Subject: Post Permit Revision 1 - Summary Letter

Project: 6221 83rd Pl, Mercer Island, WA 98040  
MI Project # 2207-110

**A4.3**

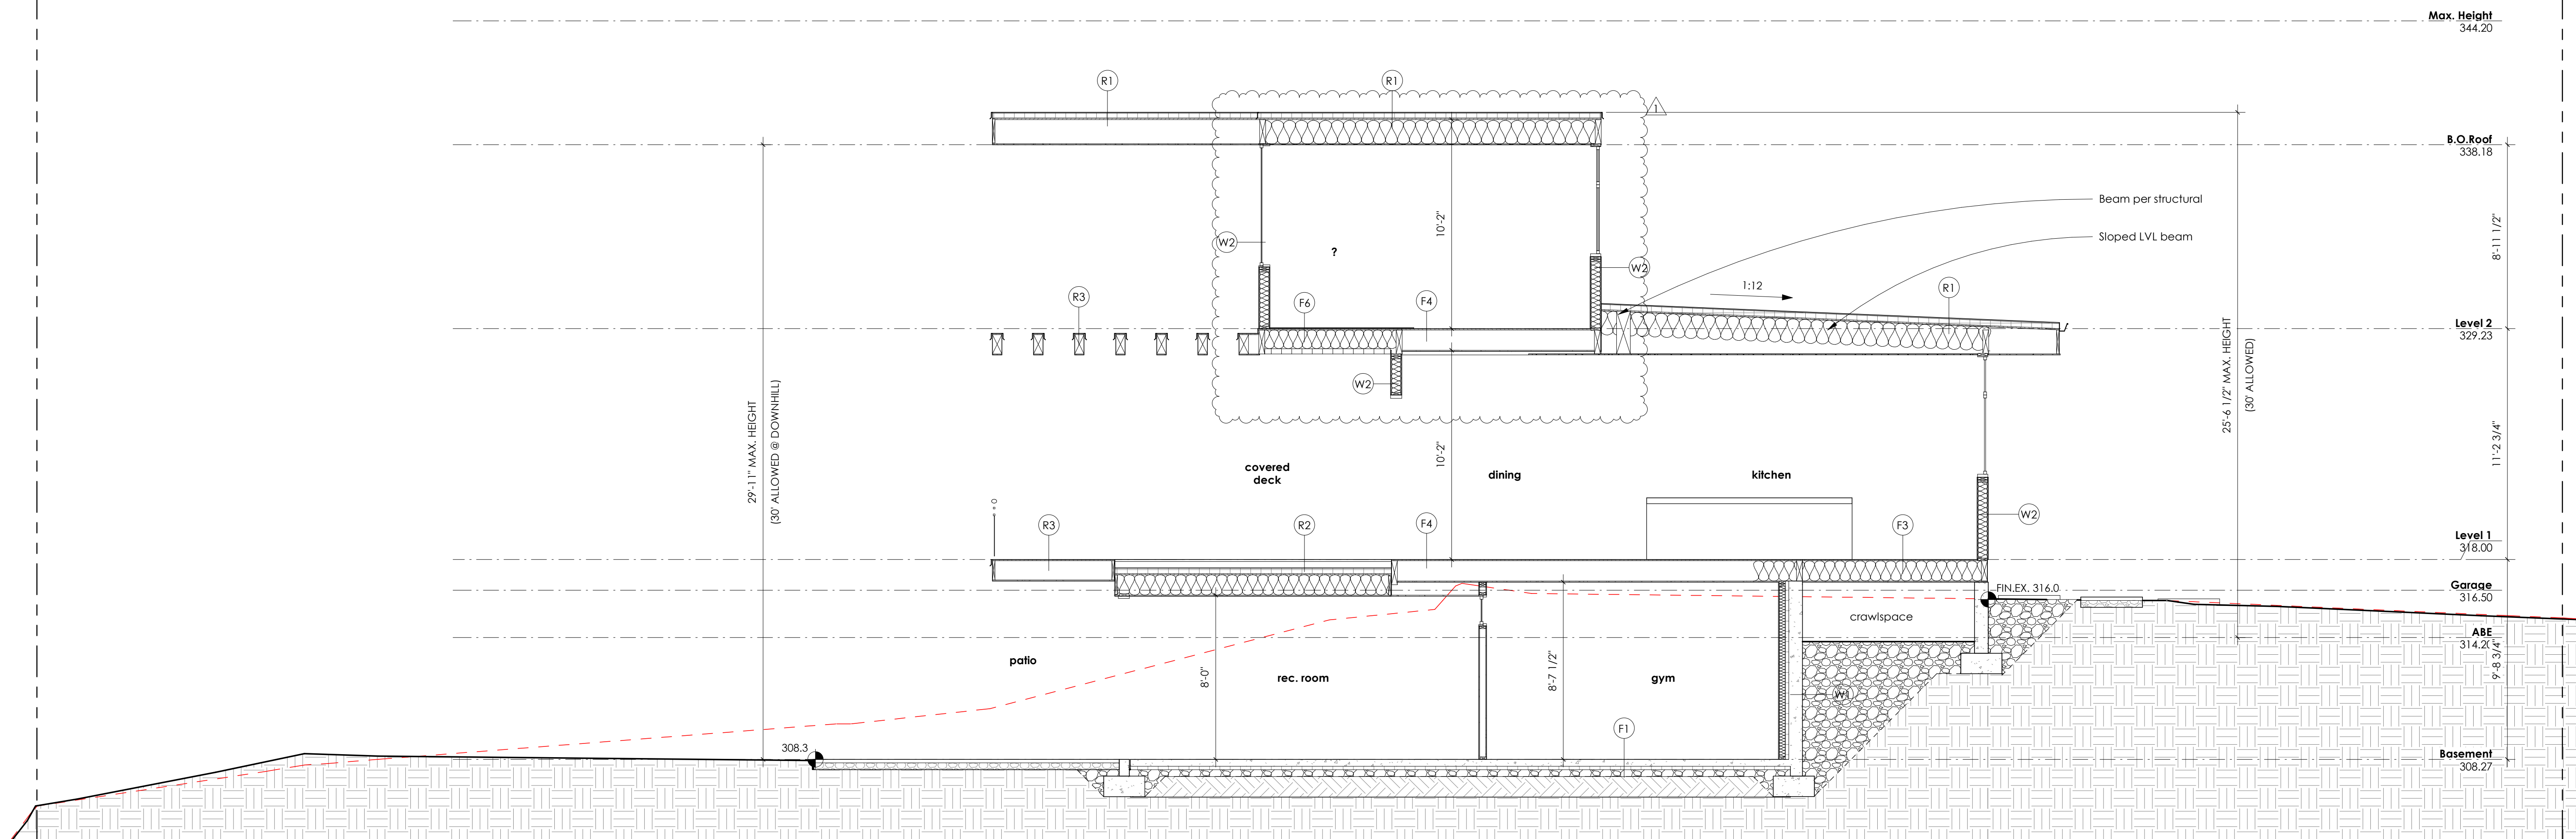
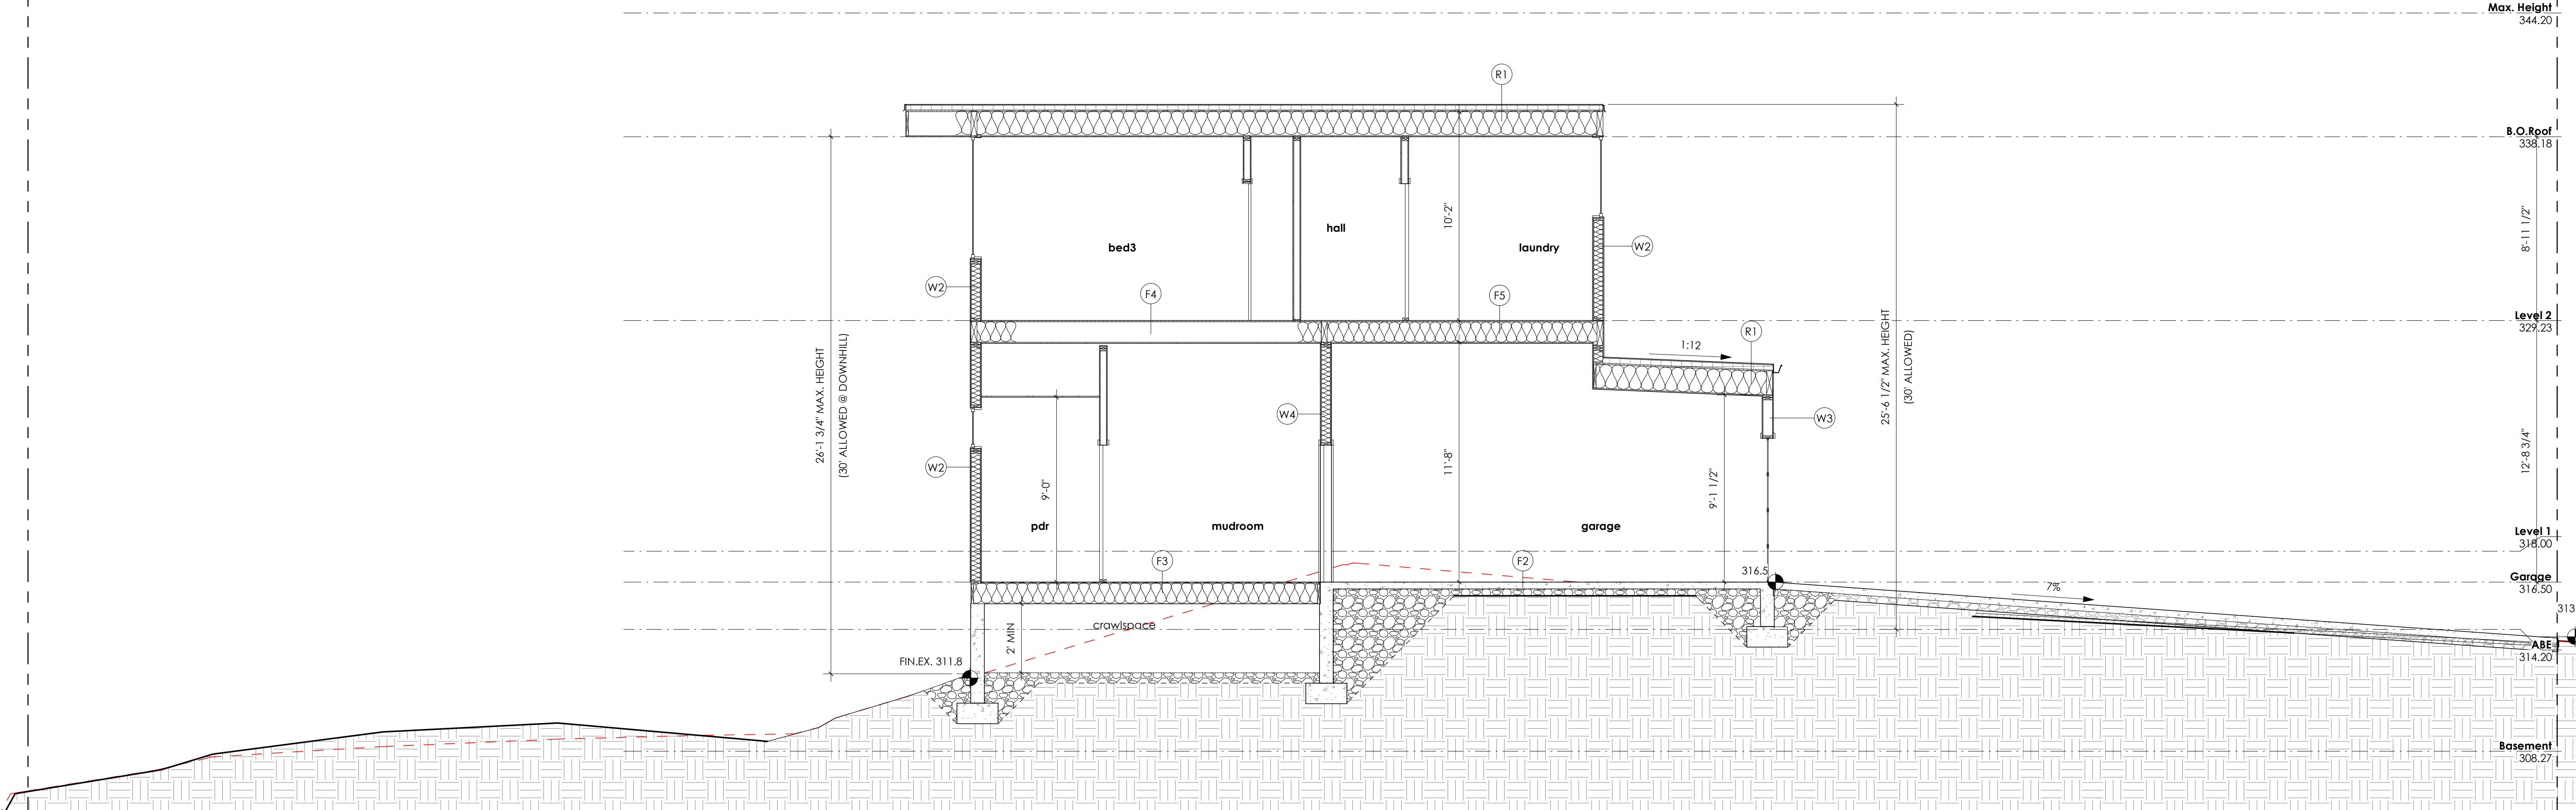
- A4.0 – Glazing – Windows R and T
- A4.1 – Assemblies – F4 thickness revised
- A4.2 and A4.3 – Sections – Window revision and width of master bathroom
- S2.1 – S2.4 – Plans reflect architectural changes
